**A57 Link Roads**

**9.72 Addendum to the Statement of  
Common Ground with High Peak Borough  
Council**

- 1.1.1. This document provides an update on the ongoing dialogue with High Peak Borough Council in relation to Air Quality matters. The document has been produced in response to the Issue Specific Hearing 3 held on the 5<sup>th</sup> of April 2022 in lieu of a full update to the Statement of Common Ground with High Peak Borough Council (REP2-018).

Drawing Number	HE551473 - BBA - EGN - A57_AL_SCHEME - DR - LE - 060414
Location	Location
Scale	1:5,000
Original Size	A3
Rev	P01

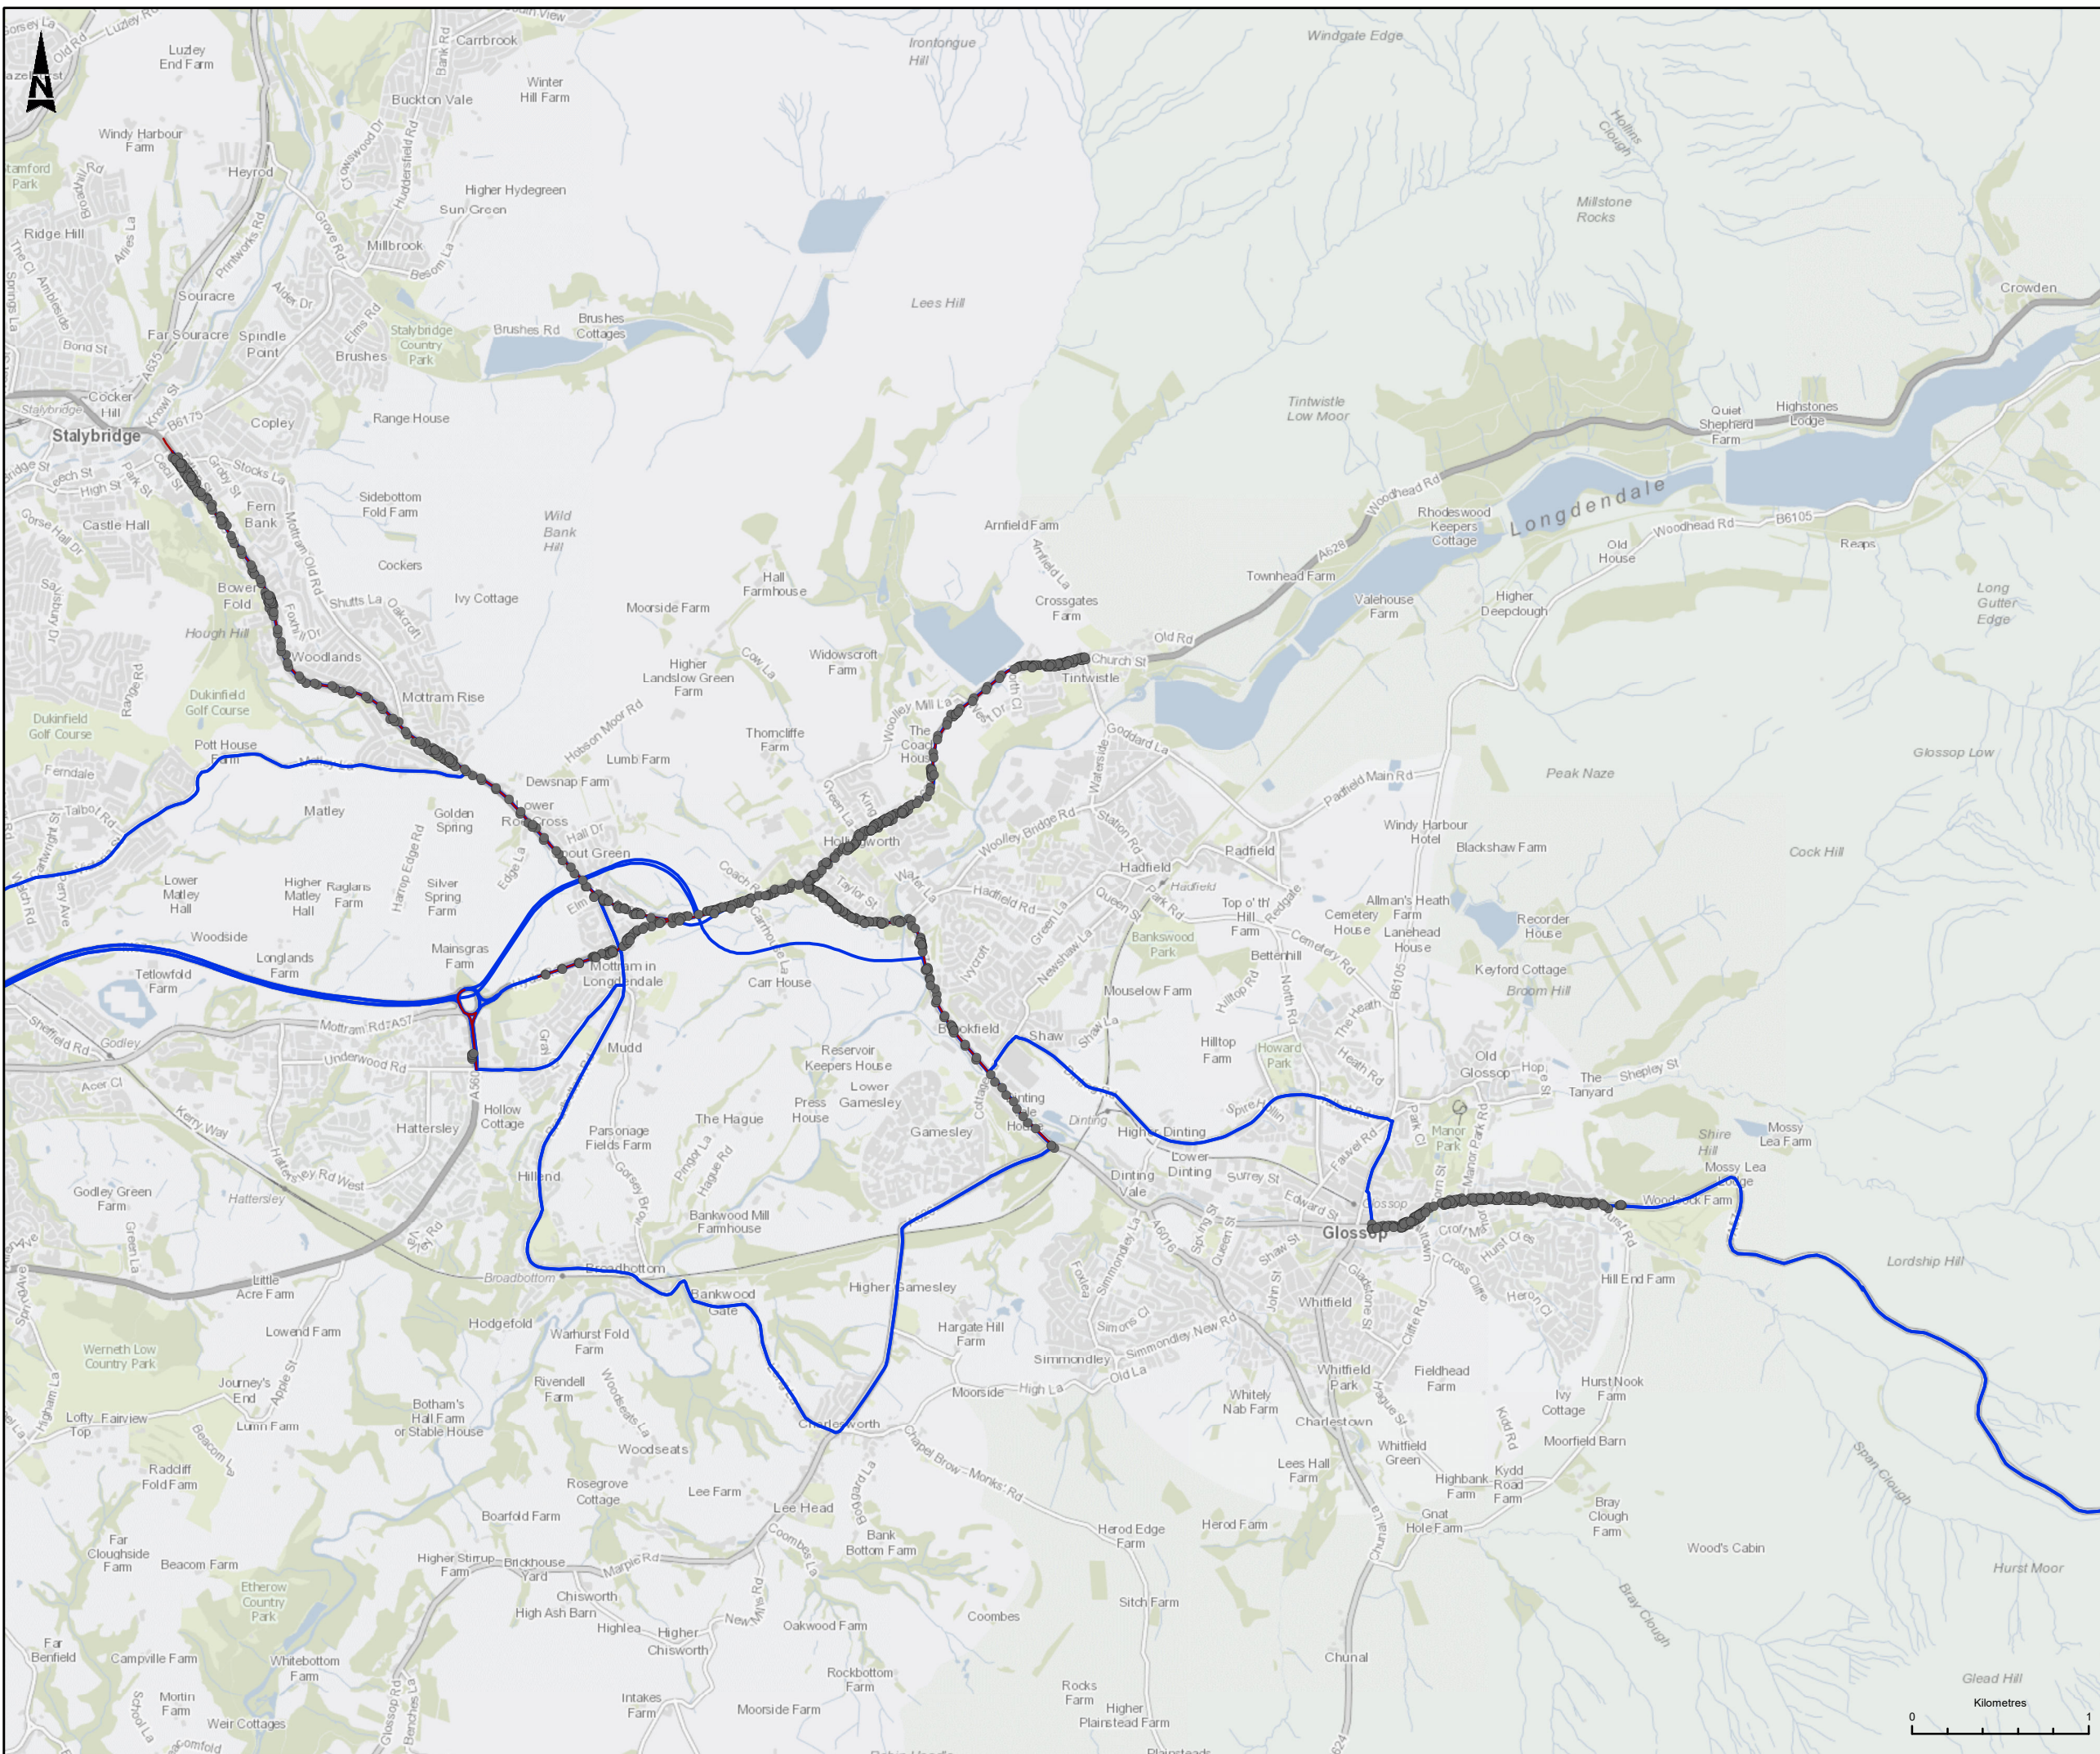
<b><u>Figure 5.4 Air Quality Compliance Risk Assessment – receptor labels</u></b>

HPBC Item	National Highways Position	HPBC Position	Status
<p><u>Item 8.38</u>            HPBC [REP4-011] asked for the A57 Brookfield qualifying features used in the NO2 compliance assessment to be labelled on ES Figure 5.4 [APP-080].</p>	<p>Given the number of qualifying features and public access receptors included in the compliance assessment it was not possible to practically label the qualifying features in ES Figure 5.4 (APP-080) however, an extract of ES Figure 5.4 zoomed in on the A57 Brookfield area with receptor ID labels for qualifying features and public access receptors adjacent to the A57 Brookfield is provided below this table.</p>	<p>Agreed  <u>Deadline 8 update (HPBC)</u>            It is noted that this response was supplied at deadline 7 by NH. Clarification of receptors did highlight that there were some relevant receptors in the Brookfield area that had not been included in general AQ assessment but had been included in the compliance assessment (see final row)</p>	<p>Closed</p>
